Comments Regarding Condition 3

Application No: BN/127/21/DOC
Registered: 27th September 2021
Site Address: Land At Angels Nursery Yapton Road Barnham PO22 0AY
Description of Works: Approval of details reserved by condition imposed under BE/84/20/PL relating to conditions 3-as built drawings of implemented SuDS scheme & 5-updated copy of management manual or confirmation that no changes are required to manual.

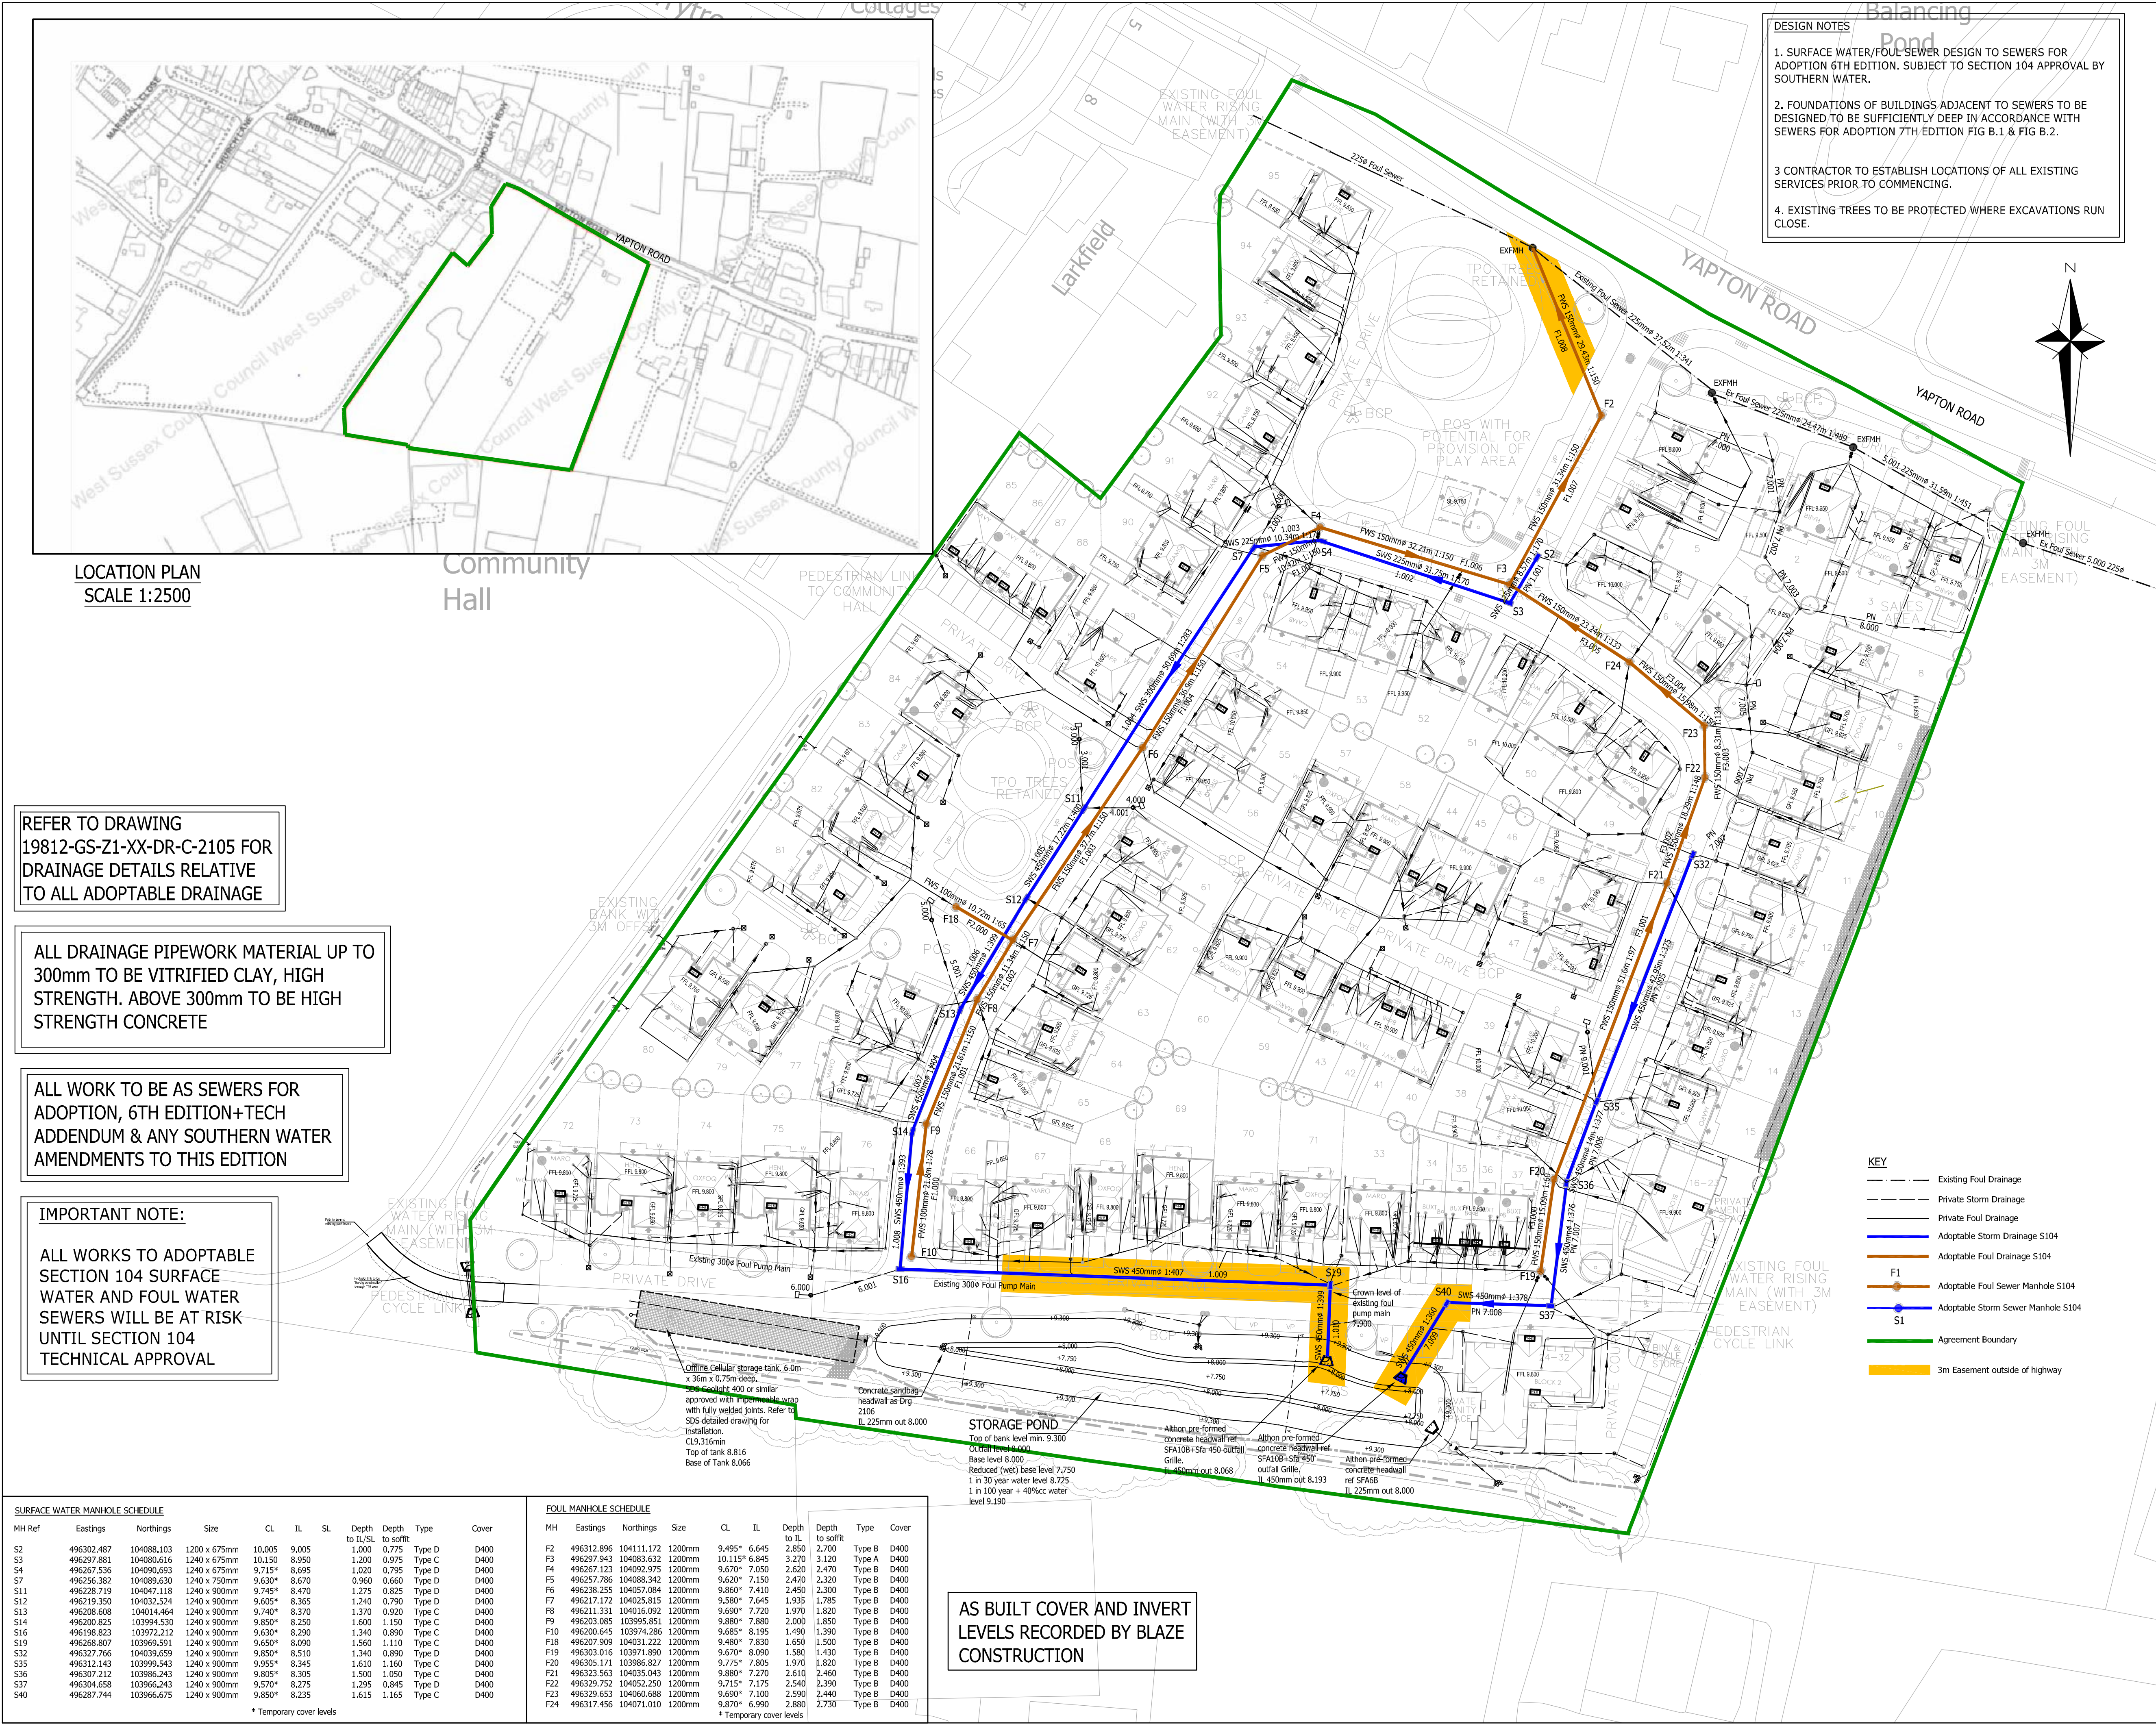
Please supply as built drawings.

124 mm QR4F Type Vortex Flow Control

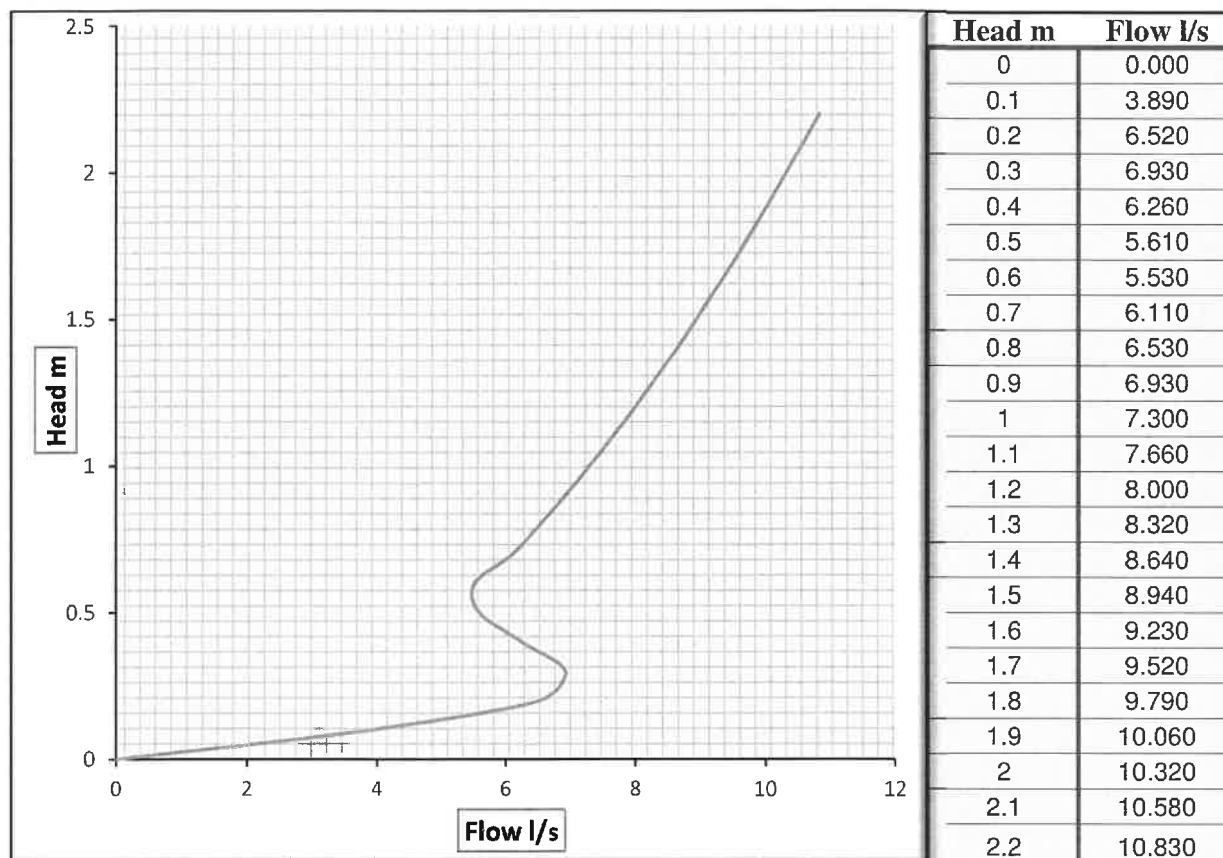
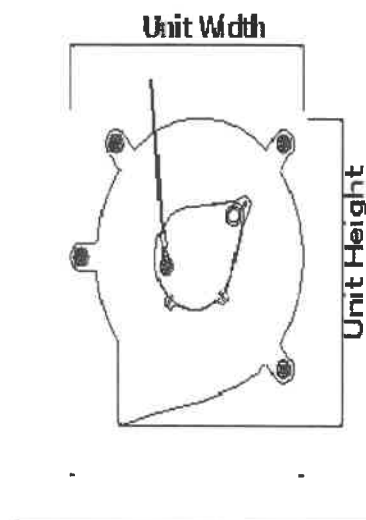
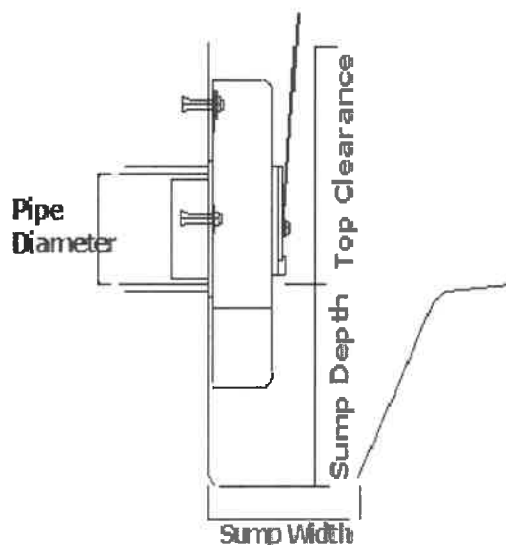
Please supply evidence that the appropriate flow control devices have been installed as per the design.
